Our ref: OR-0006073/01
Your ref: BC0410001 and TR0510002
Date: 16 June 2026

ENVIRONMENT AGENCY RESPONSE TO DOCUMENTS SUBMITTED AT DEADLINE 4.

EAST MIDLANDS GATEWAY PHASE 2 AND EAST MIDLANDS GATEWAY RAIL FREIGHT INTERCHANGE MATERIAL CHANGE

**Appendix 04 – Silt Management Plan**

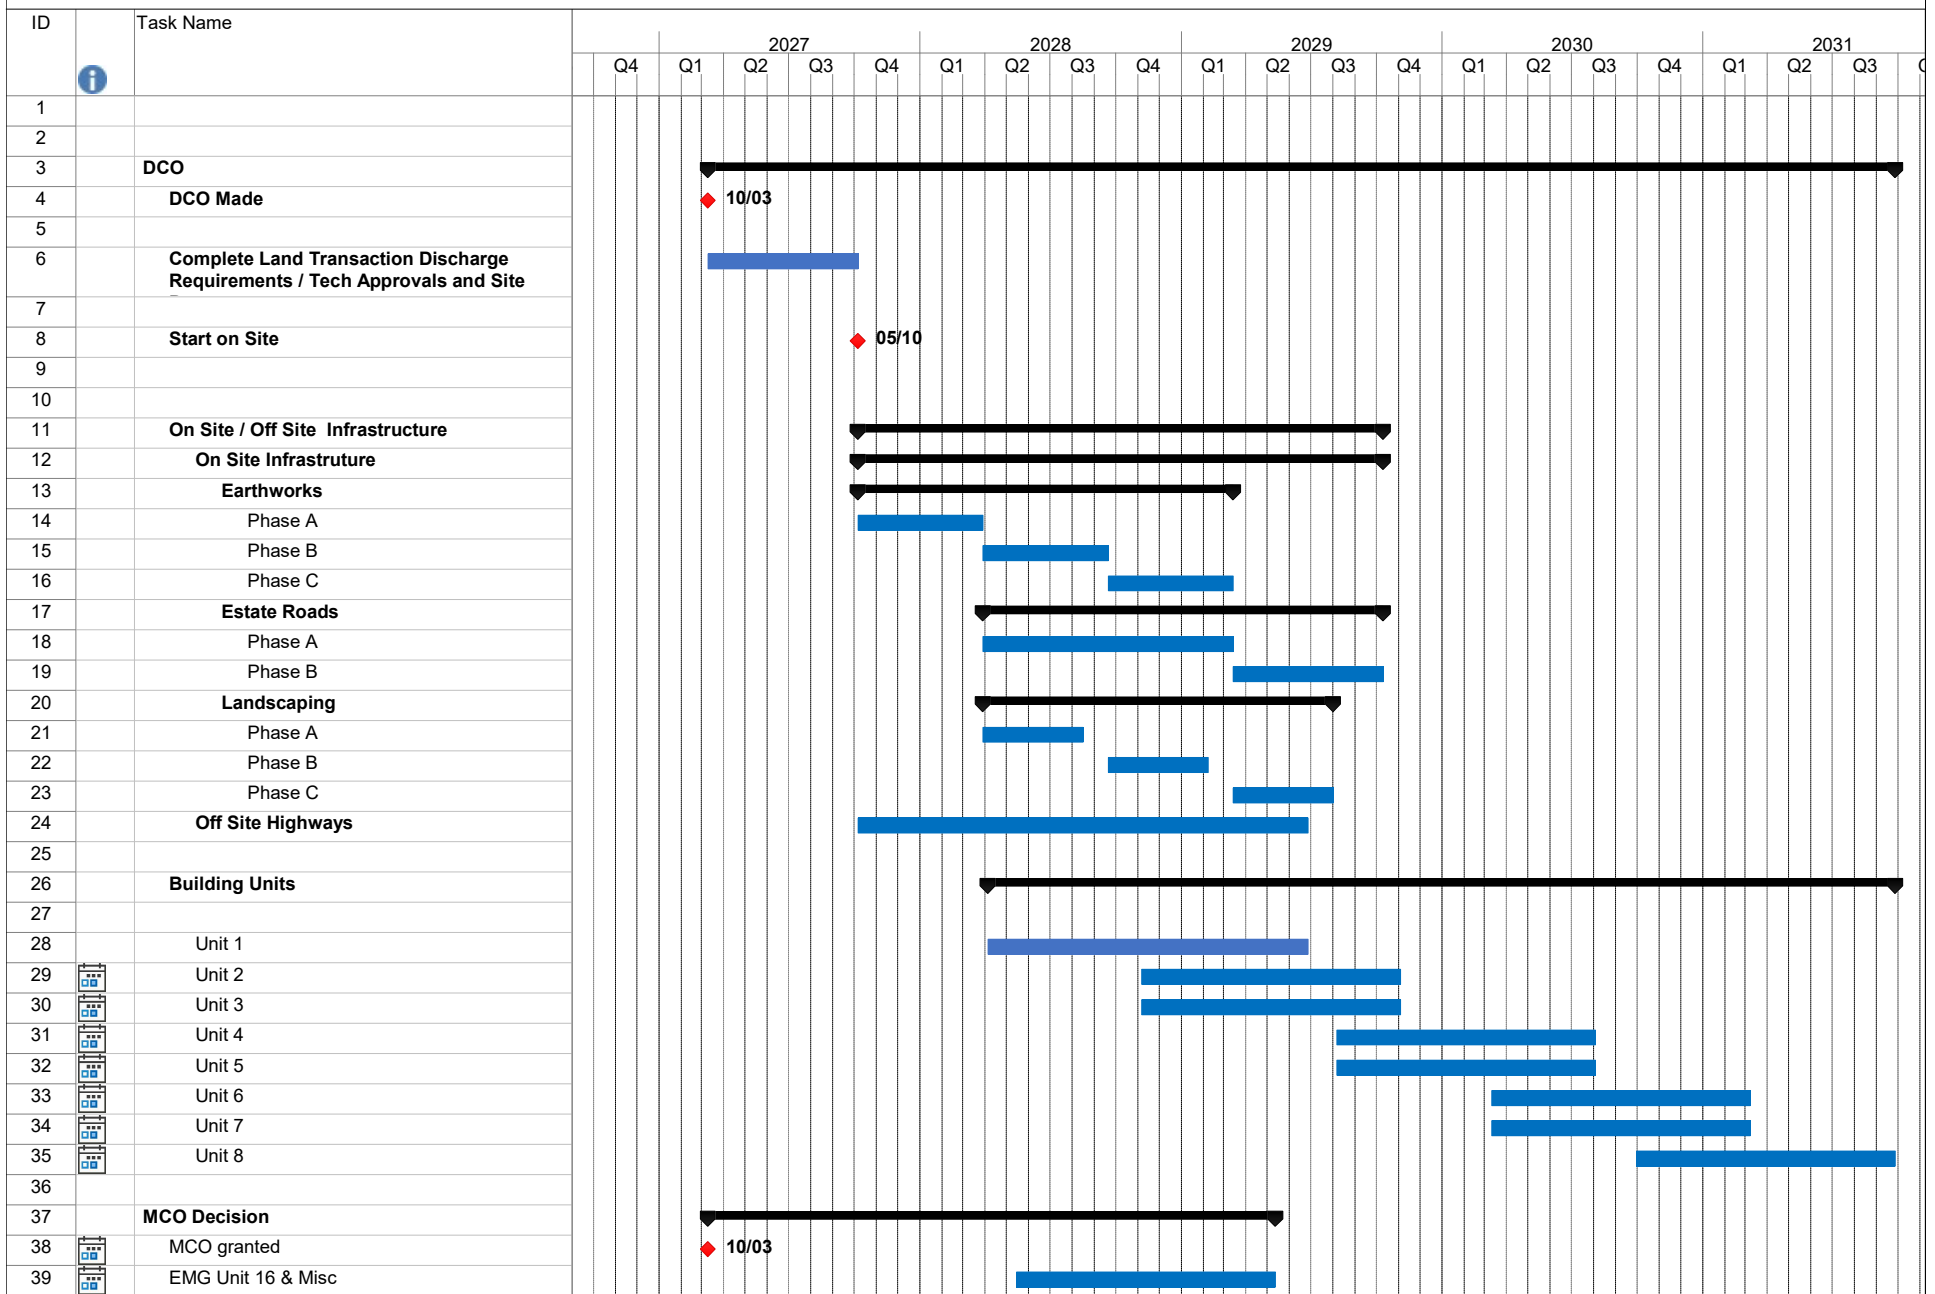
“A draft water quality monitoring plan is provided in Appendix A of the SMP” [Outline Silt Management Plan], however this appears to be incorrect. Appendix A is diagrams of silt deployment guides. We request the Applicant confirms where they believe extra details are included in the SMP. Whilst locations and methods may not be able to be committed to at this stage, most projects can specify a frequency of at least monthly and state that some form in in-situ testing and water sampling will occur.
